**WEST SUSSEX COUNTY COUNCIL
PLANNING SERVICES CONSULTATION**

SUBJECT: LU/278/17/RES - Approval of Reserved Matters following Outline Permission LU/47/11 for Construction of the southern section of the Lyminster Bypass, including northern and southern roundabouts, surface water drainage and landscaping. Departure from the Development Plan and affects a Public Right of Way.

LOCATION: North Littlehampton Strategic Development Site, Land West of Toddington Park, Toddington Lane, Littlehampton, BN17 7PP.

This is the second WSCC highways and transport response to the planning application for approval of reserved matters following Outline Permission LU/47/11 for Construction of the southern section of the Lyminster Bypass, including northern and southern roundabouts, surface water drainage and landscaping.

1. **WYG – Landscaping proposals SLB2 Plant Schedule 2 of 2 – A088461 SLB1-SLB4.dwg - August 2017.**

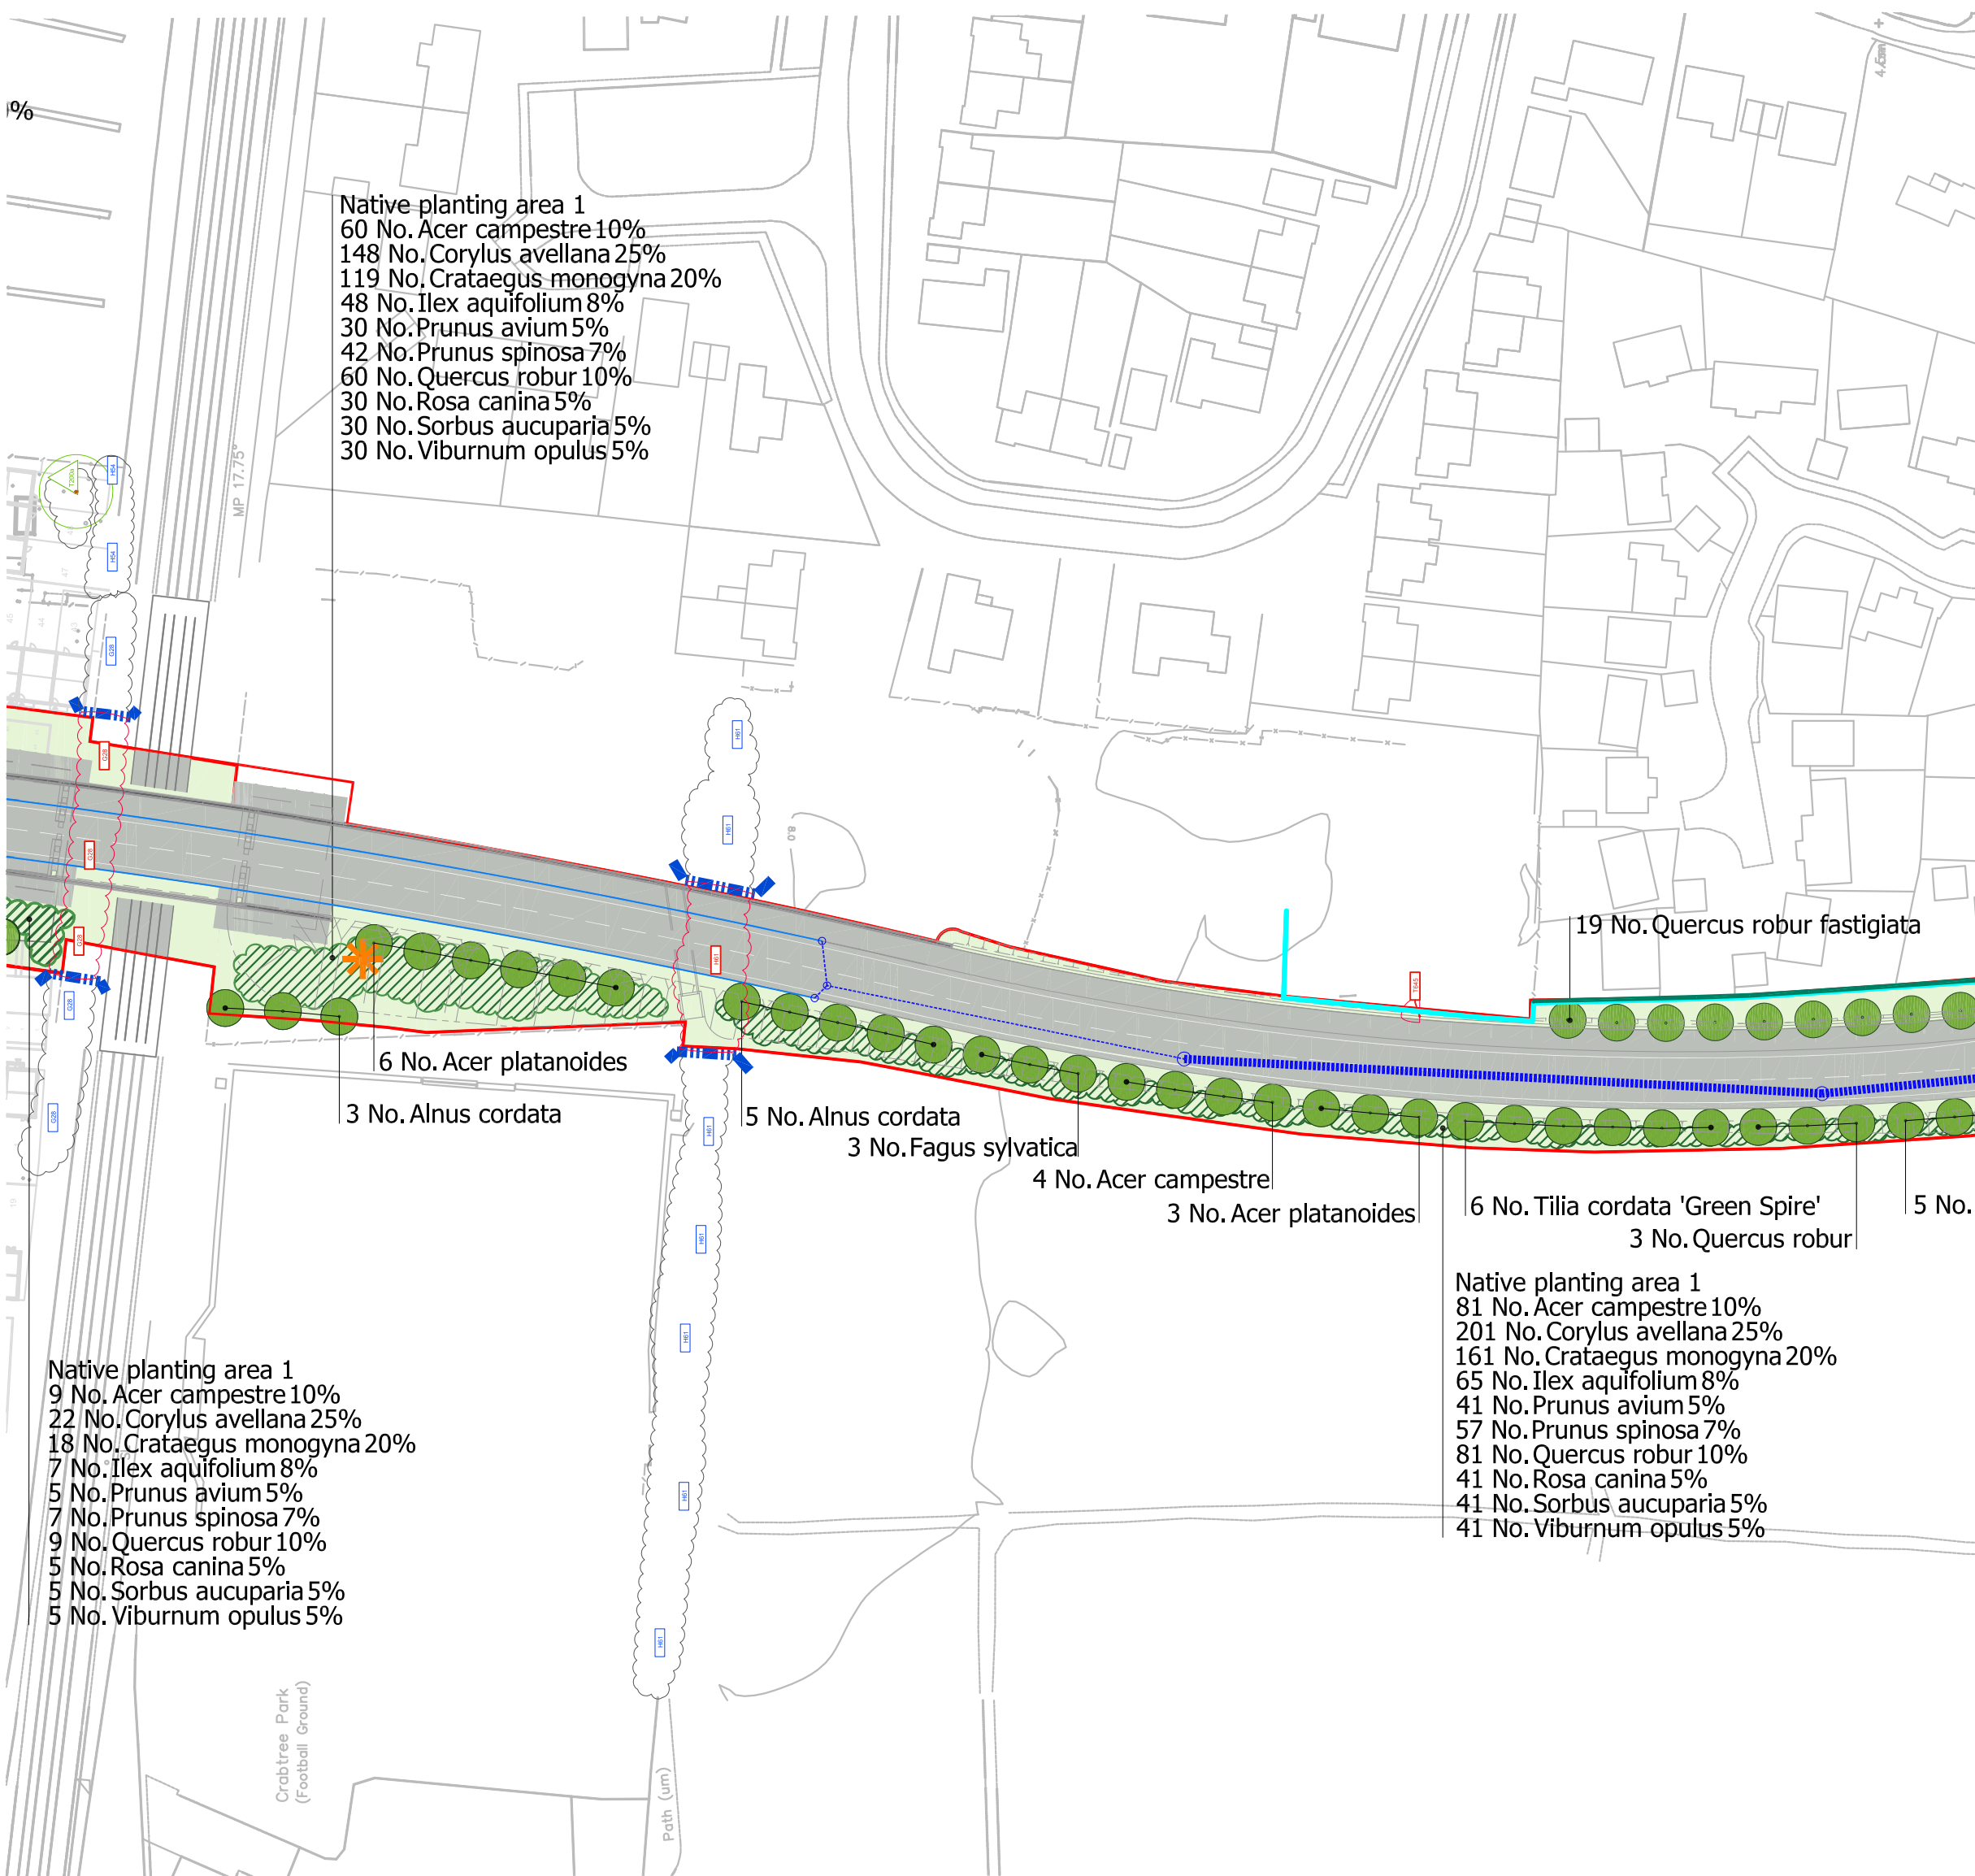
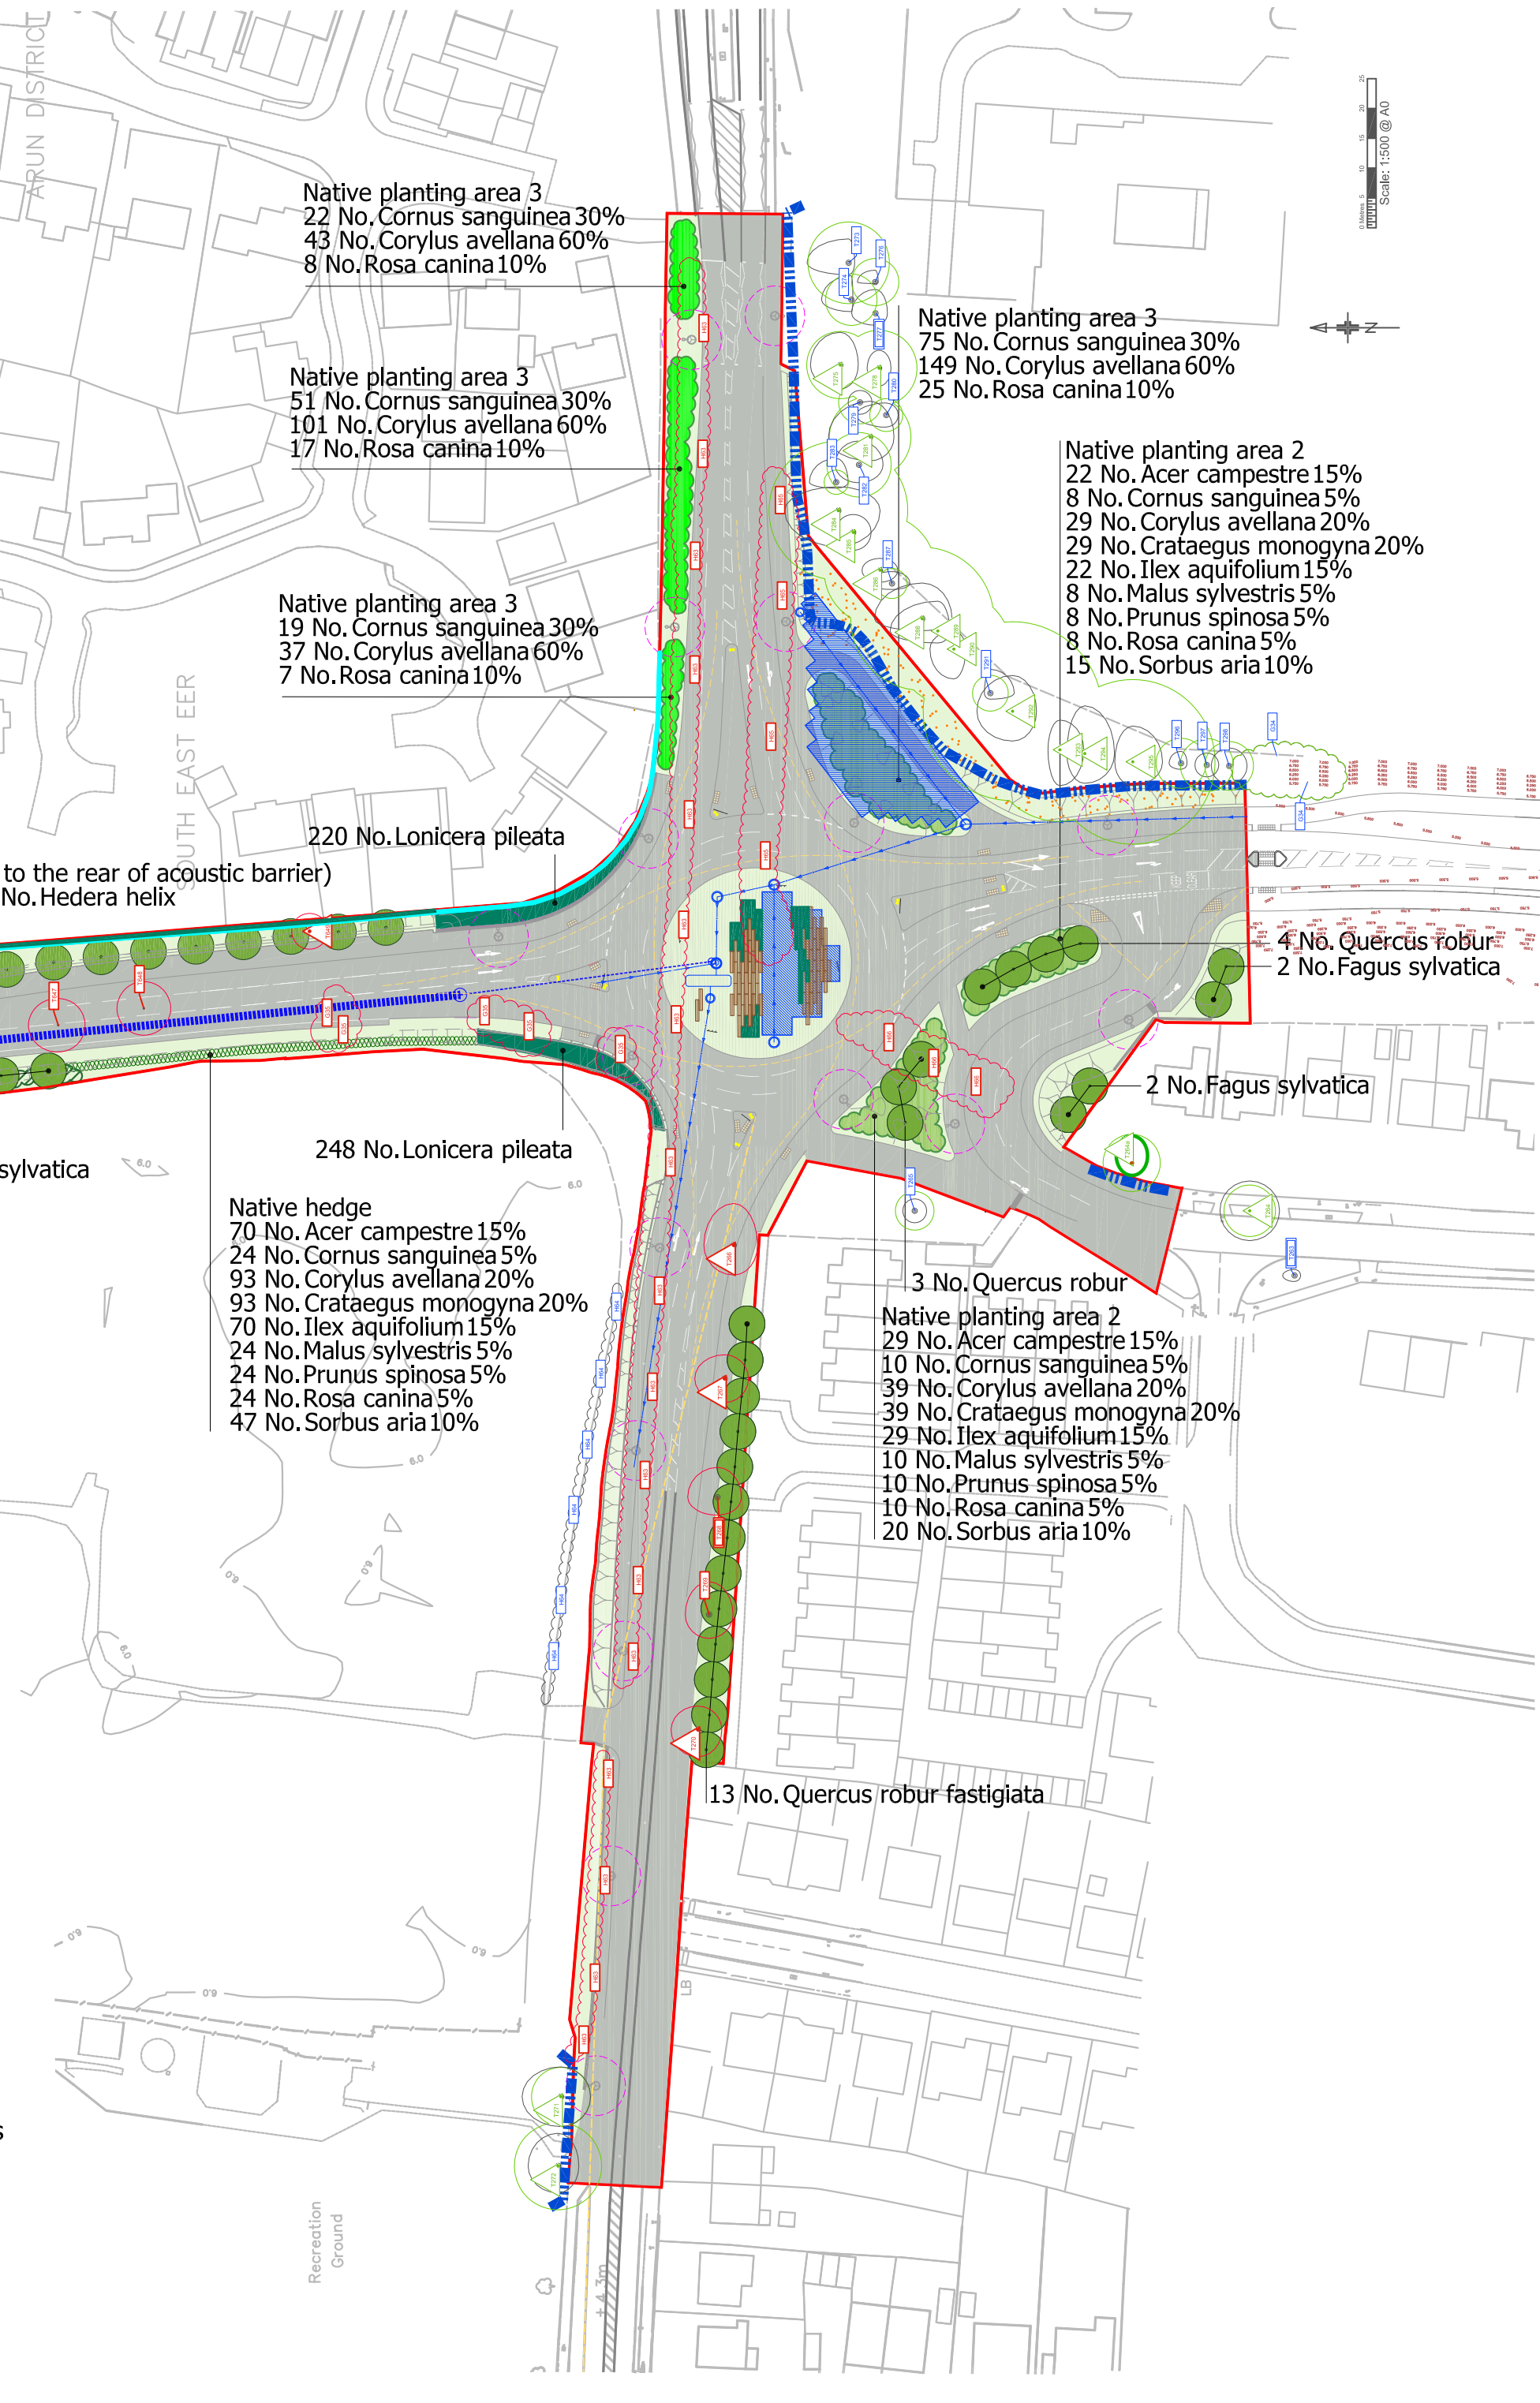
- Visibility reqs. at points where visibility splays are required (ped and vehicular).
- Continuity of cycle route alongside re-aligned Highdown Drive (currently not overly clear on drawings) – maybe a detailed design consideration.
- Safety barriers and the like on the bridges themselves and on the abutments need to be shown and checked leading up to the bridges must be suitably designed to cater for all users. Specifically on the bridges, guardrail heights where cyclists run close to them need to be higher than those used simply for footways. Applicant to show.
- Applicant to demonstrate that cycle path is wide enough and has enough clearance/suitable buffer-zone between carriageway. This has now been shown.
